MEMORANDUM

DATE: April 28, 2023
Response: October 4, 2024

SUBJECT: SF-23-007 – Waterbury Filing No. 1
First Submittal

Engineering Division

WATERBURY FILING NO. 1
 CONSTRUCTION SET
 ROUNDABOUT DETAILED GRADING

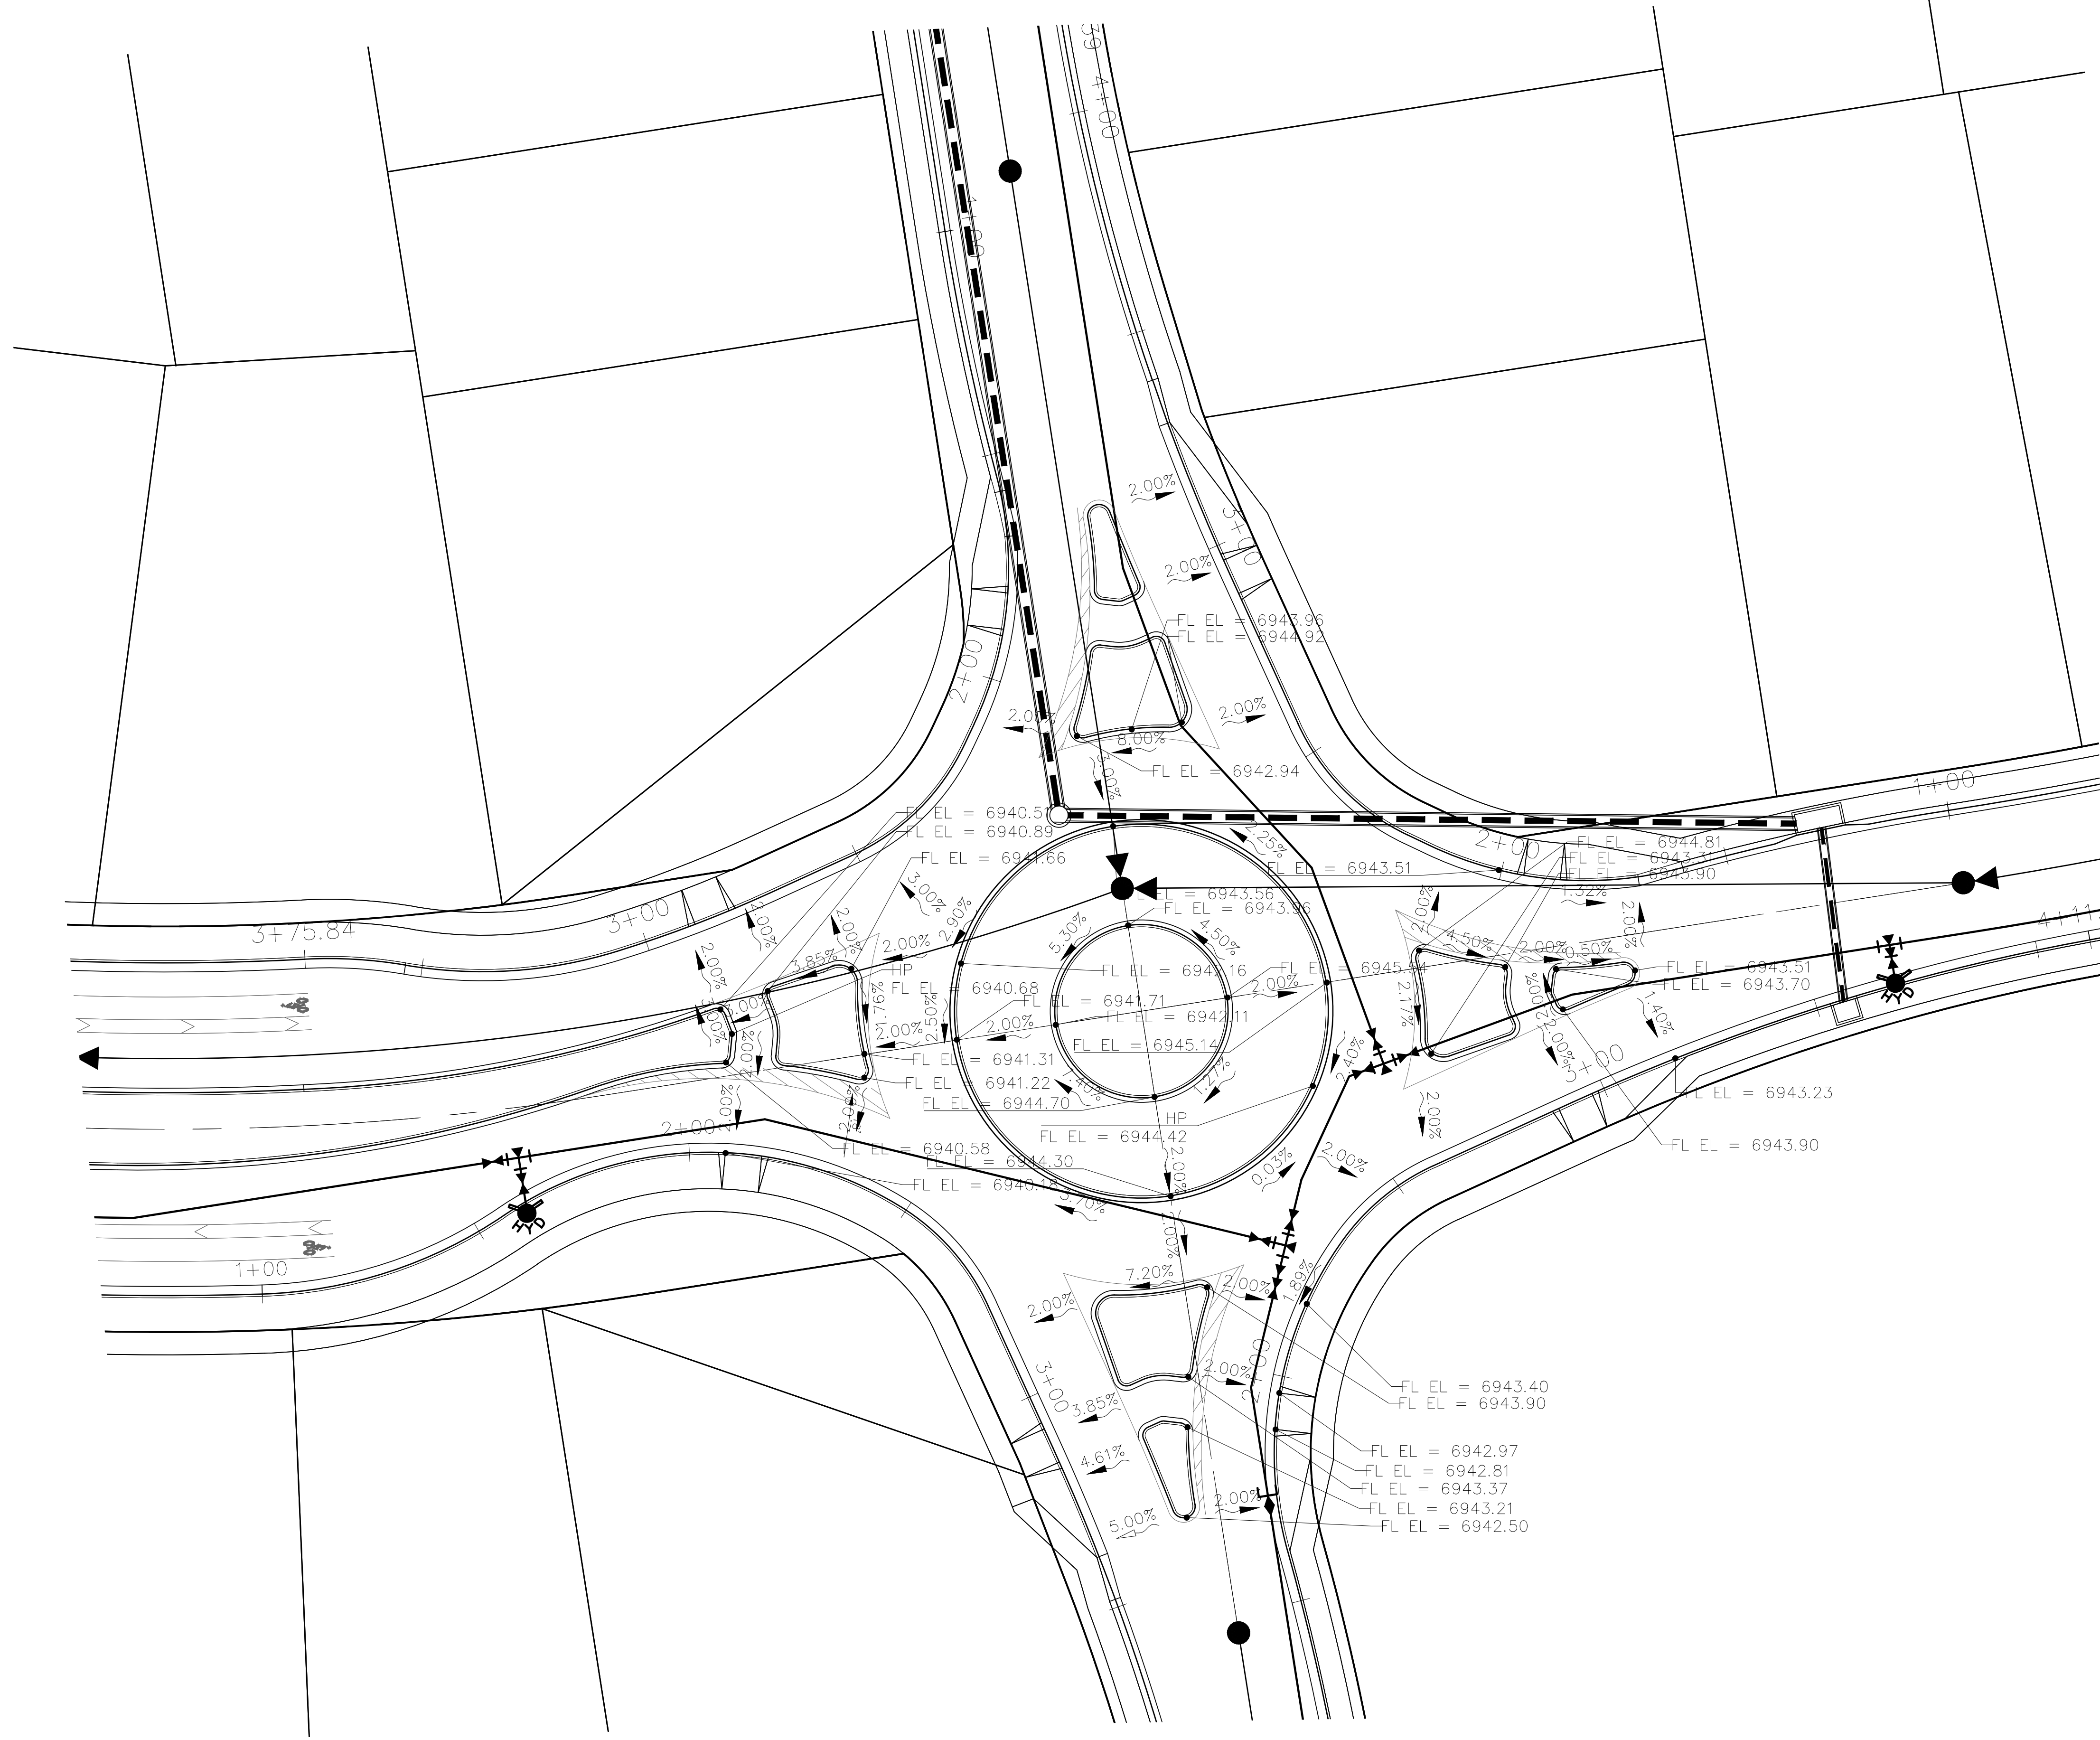
1. See Letter of Intent redlines. Done
2. Access for the lots around the roundabout is a critical issue and will need to be resolved prior to resubmittal. We showed locations on roundabout design where we believe they will work.
